11 April 2022
Ref: W2635

Application reference FG/54/22/PL
Land rear of 1 Sea Drive Ferring BN12 5HD

1 No new dwelling. This application is in CIL Zone 4 and is CIL Liable as new dwelling.

Project: New build dwelling		
for SB24 Ltd		
at		
Land to Rear of 1 Sea Drive Ferring Worthing BN12 5HD		Contact: Michael Austin RIBA E-mail: project@austinlebbon.co.uk Web: www.austinlebbon.co.uk Phone: 01730 887559
Dwg Ref: 2114 [PL] 03	Rev: -	Date: Feb 2022

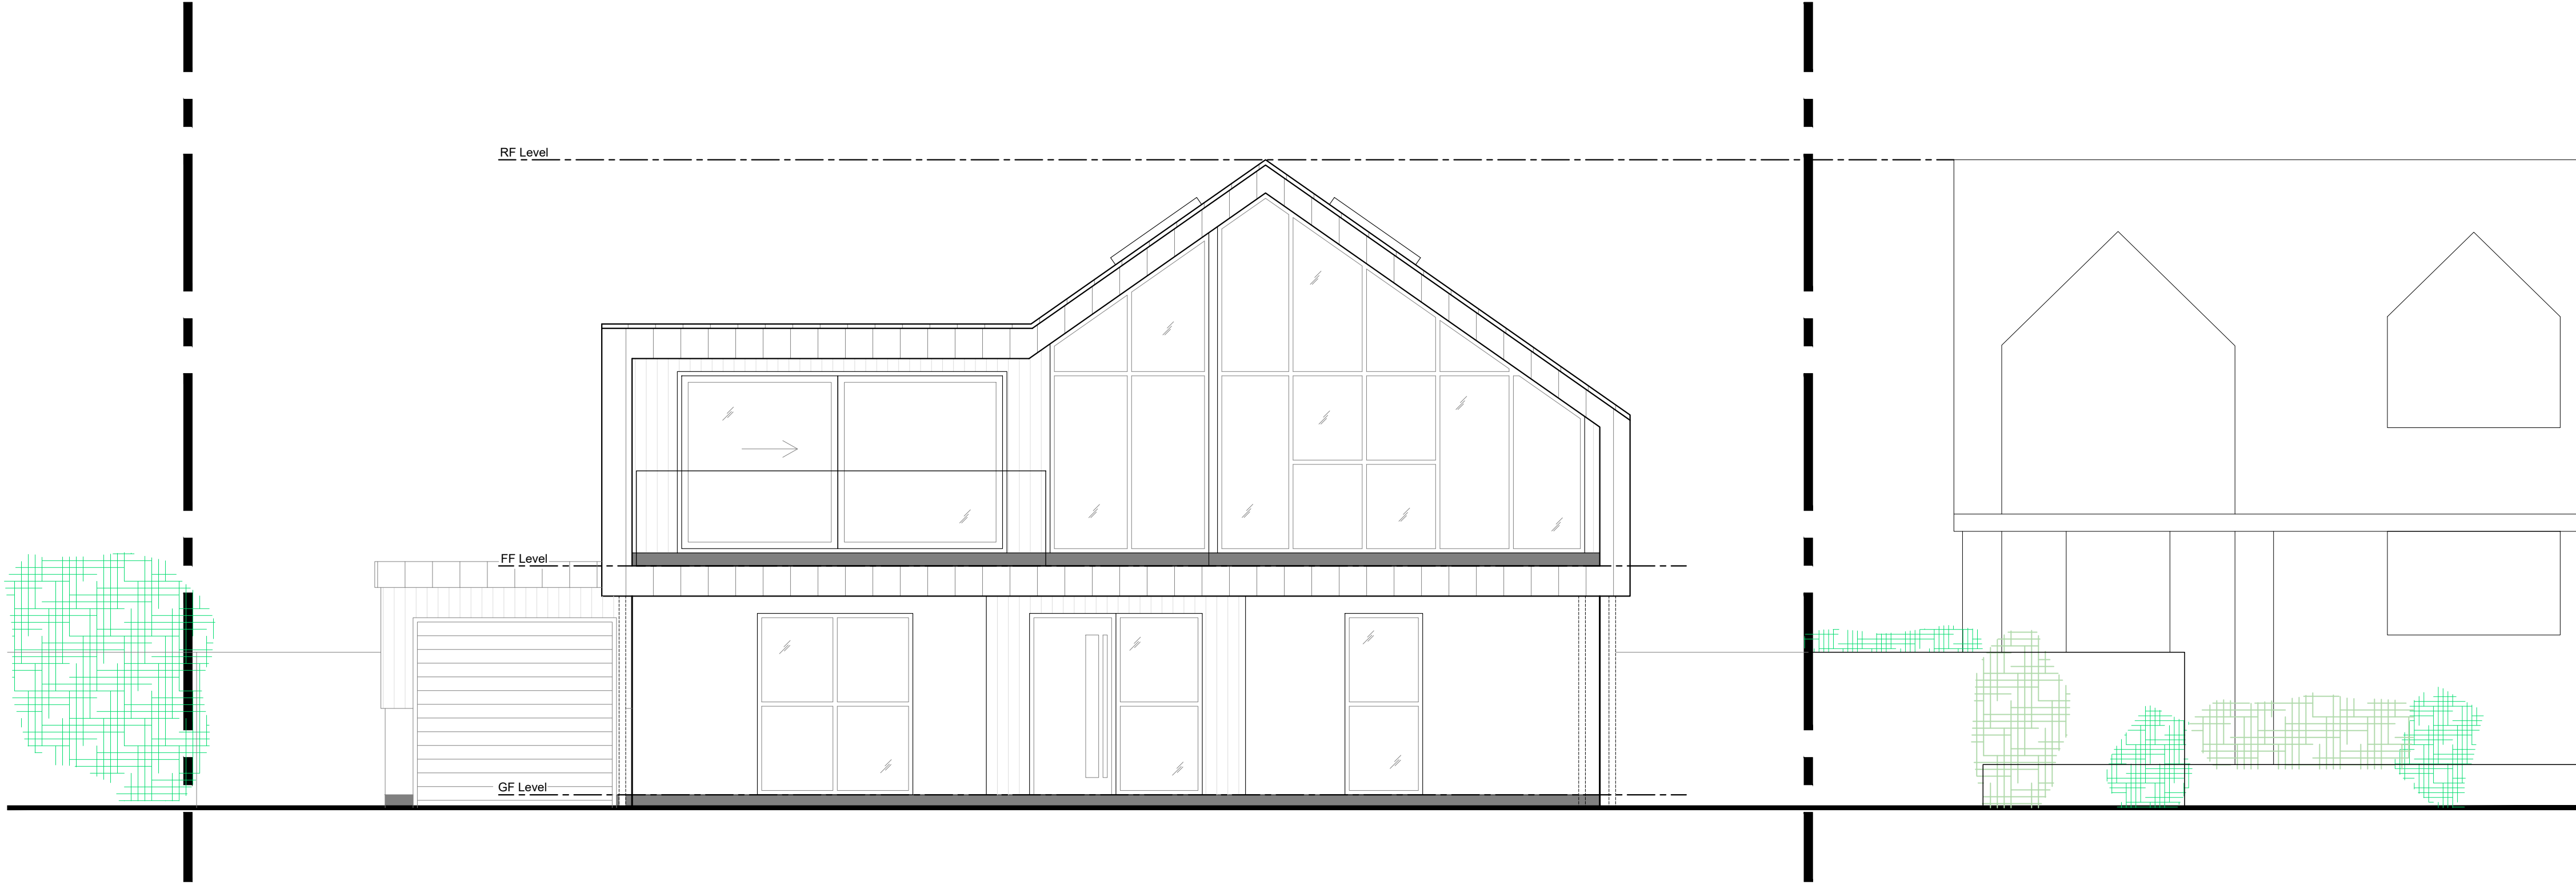
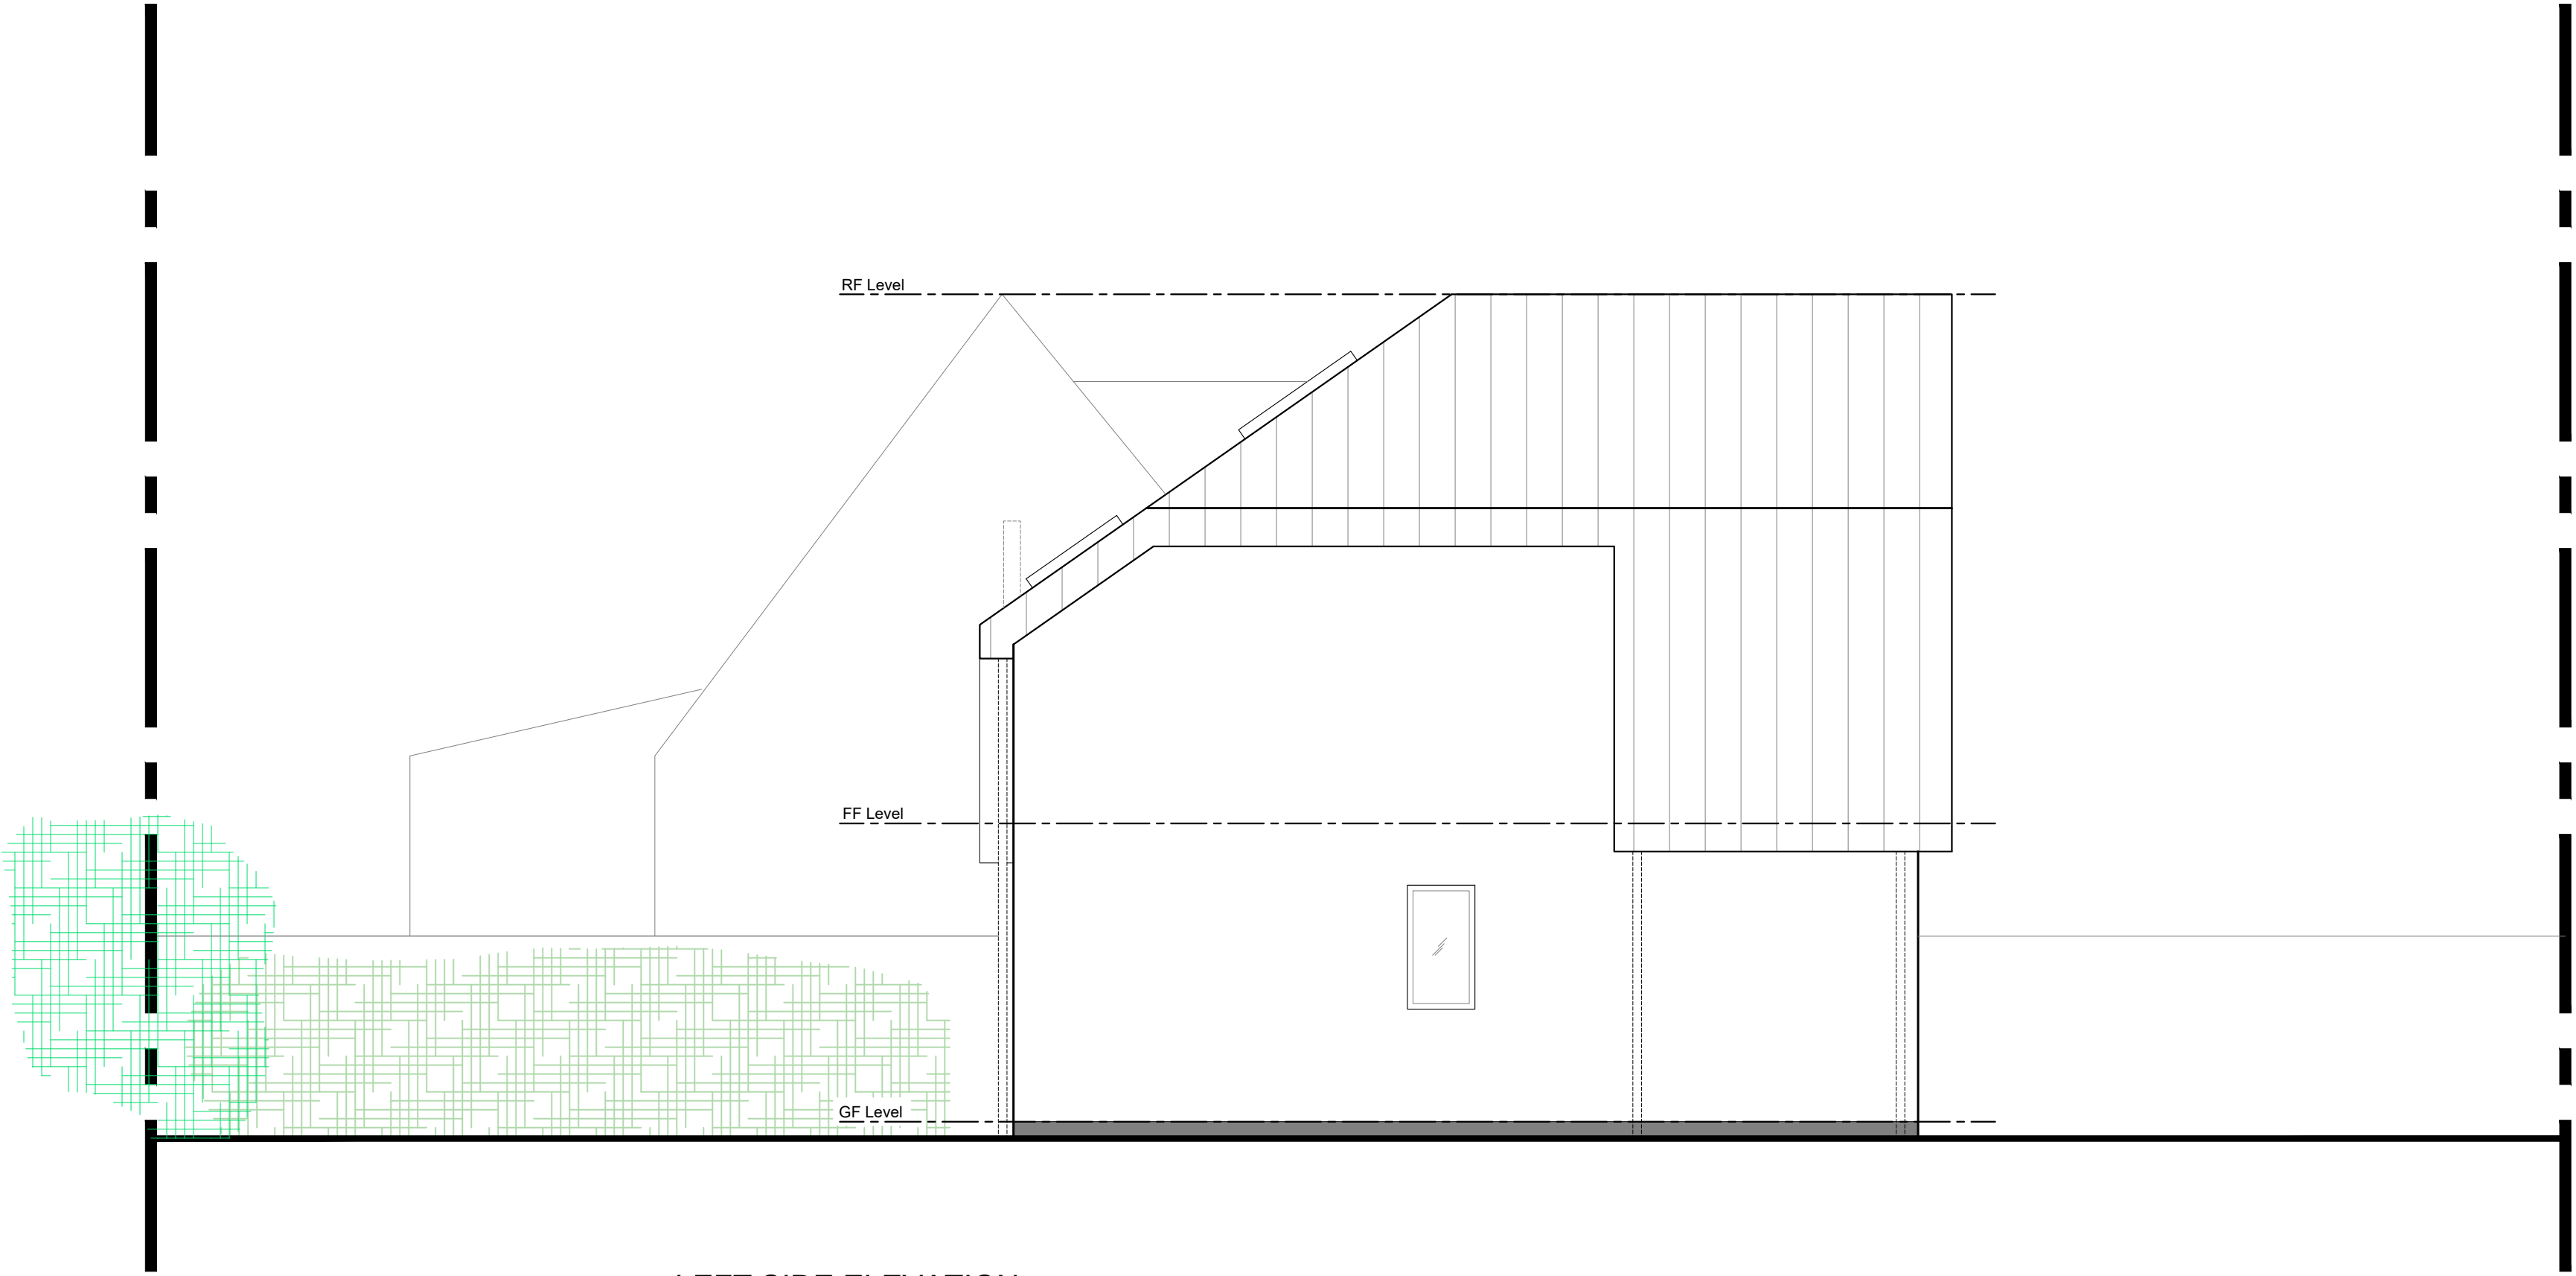
- Use materials to match those used within the surrounding area
14. The proposed dwelling would be set 5.1m forward of the building line and the roof form would include a large full height gable to the front elevation and a pitched roof to the rear elevation. As a result, the bulk of the dwelling would be set significantly further forward than no. 108 and other dwellings to the north/south (see figures 1-3 below). The proposed dwelling would be set within close proximity to (4.1m) to southern flank wall with 108 Sea Drive and would appear cramped and overdeveloped within the street, which is comprised by dwellings set within spacious plots. The dwelling would therefore disrupt the rhythm and spacing within the street scene, as illustrated in the series of extracts from the submission shown below.

Figure 3 – Image adapted from application drawing: Proposed Front & Left Side Elevations (ref. 2114 [PL] 03) illustrating comparative siting with 108 Sea Lane (source www.arun.gov.uk)

20. The proposed dwelling would result in significant overshadowing of the ground floor living room at 108 Sea Lane due to the proposed siting of the dwelling set well forward of the building line and the close proximity to the southern flank wall of 108 Sea Lane, in combination with the eaves height, bulk at roof form and location of the proposed dwelling to the south (see fig. 3).

Proposed Site Plan
Scale 1:100 @ A1

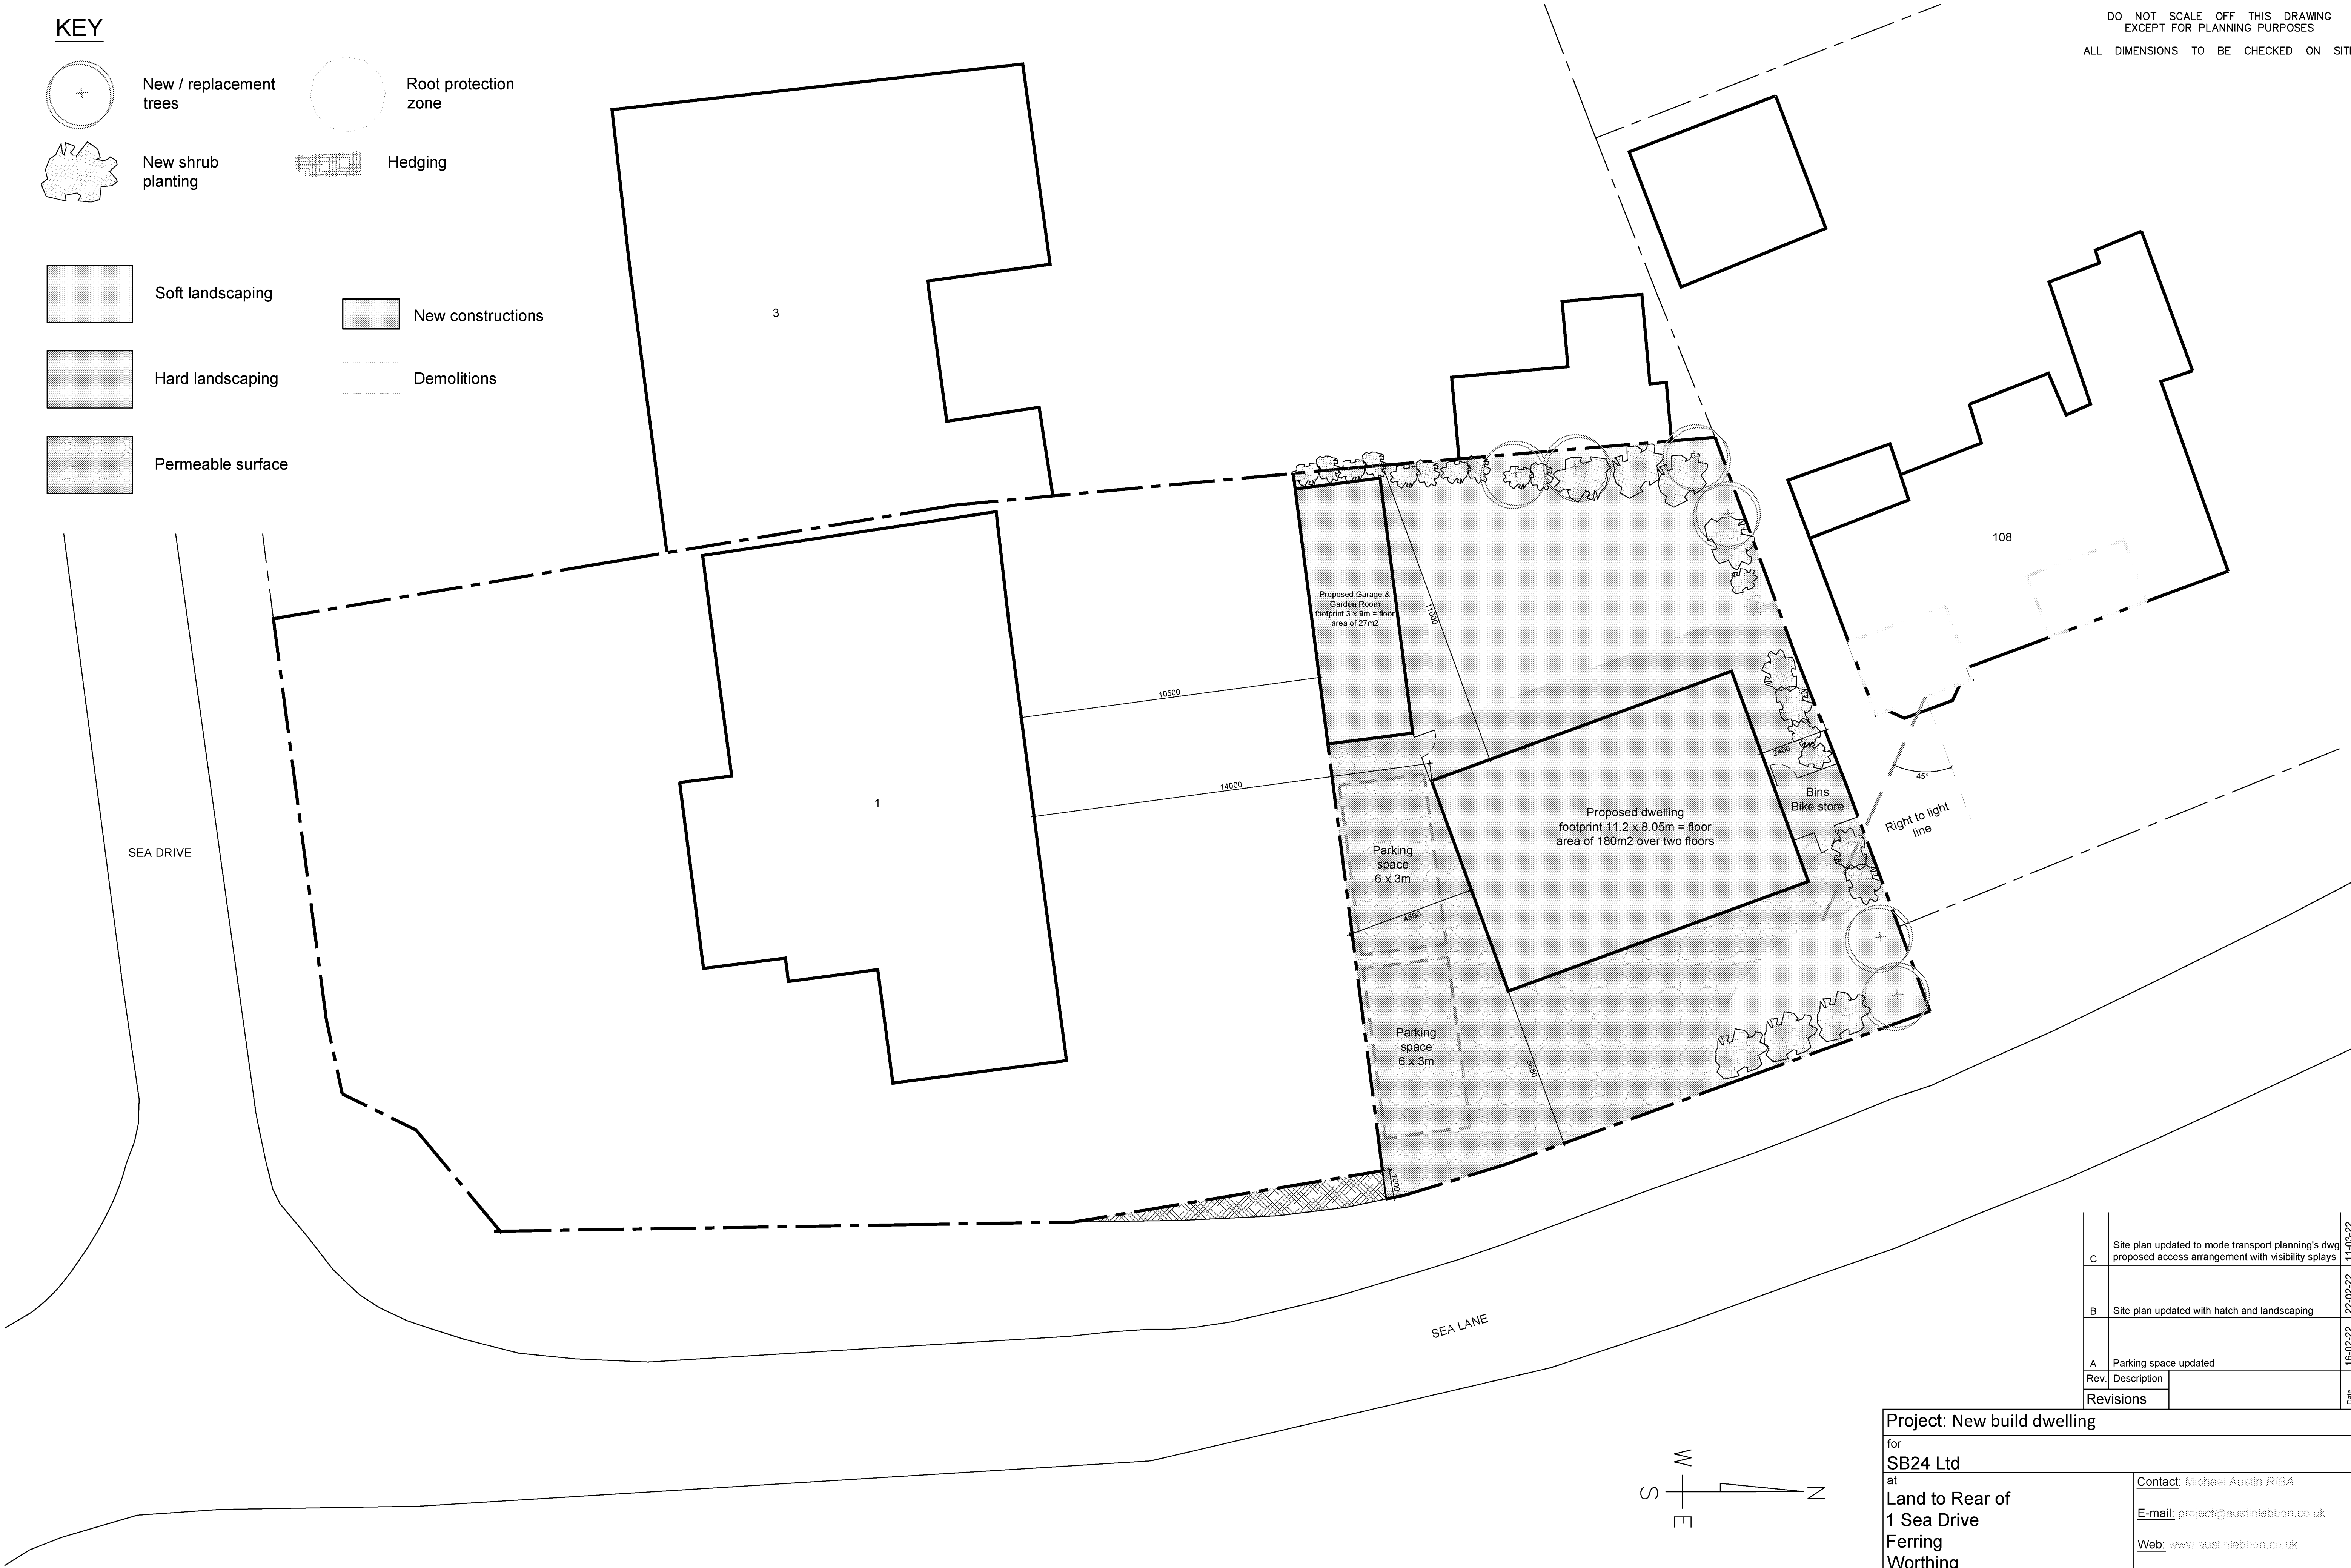
28. These concerns carry greater weight as the proposed driveway does not provide a turning space for vehicles, meaning that vehicles will need to either reverse into or out of the drive. This increases the time spent manoeuvring and limits visibility. E.g., if a car were to be reversing off the drive at a time when another car turns the corner and approaches the application property – the driver reversing out may not see the car on the road until it is too late. For these reasons

34. The proposed access to the site is reliant on vehicles entering or exiting the site in a reverse gear, close to a bend in the road, which raises highway safety concerns.
